Trees and your proposed building plans at Lane End.

You are in the process of seeking planning permission to extend your house. This is a relatively modest extension with only a very small increase in the building's "footprint." It will not involve any major site clearance although your Architect, Roland Heathcote has noted that there are a couple of small trees and a large shrub that are very close to the existing garage/workshop, which will be replaced with domestic accommodation.

Roland Heathcote has given me copies of the proposed site layout. The drawing SP1 shows the three trees in question and numbers them T1, T2 & T3. (T stands for "tree.")

SP1

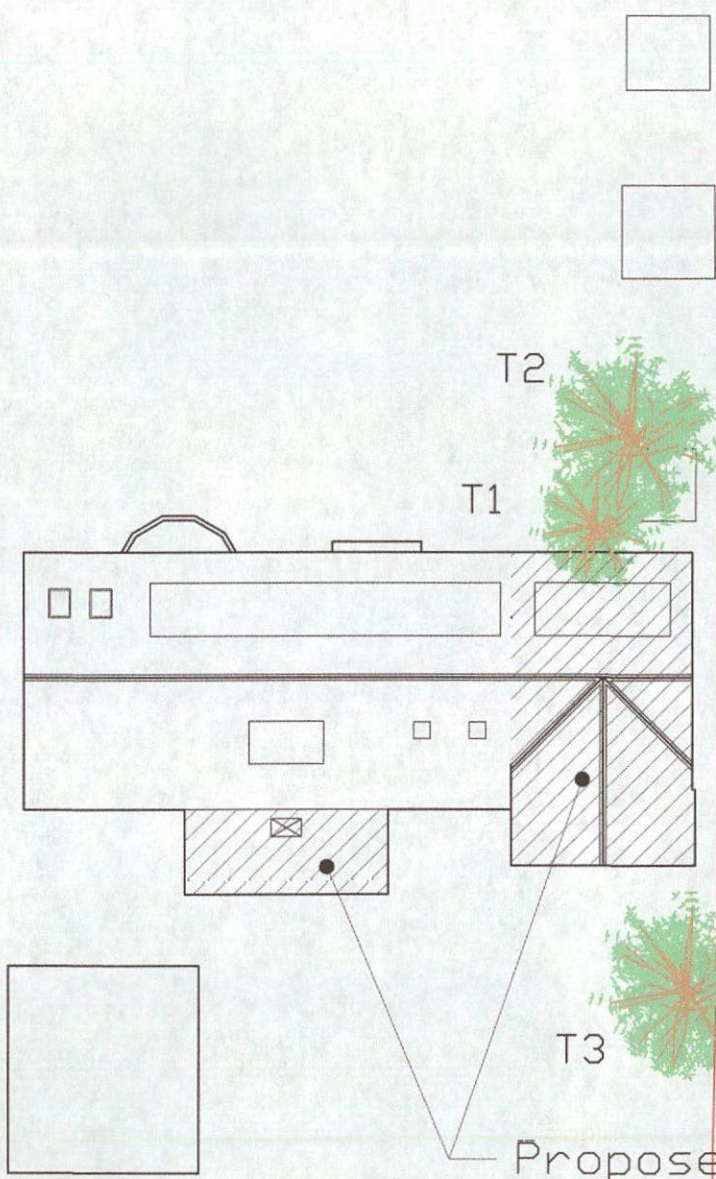
T1 is not really a tree, it's a large Magnolia shrub. It is very close to the existing building, to the rear of the house's integral garage/workshop. It is approximately 5 metres tall and has clearly been regularly pruned. It has in fact had two major stems removed to ground level. There are two more stems one of which is still quite tall, the other having been pruned away from the roof of the house.

This shrub will have to be removed if the proposed extension is to be constructed.

Photograph 4 shows T2. This is a Drummond's Maple. The cultivar arose in Europe about a century ago. The drawing identifies it as Japanese but this is incorrect.
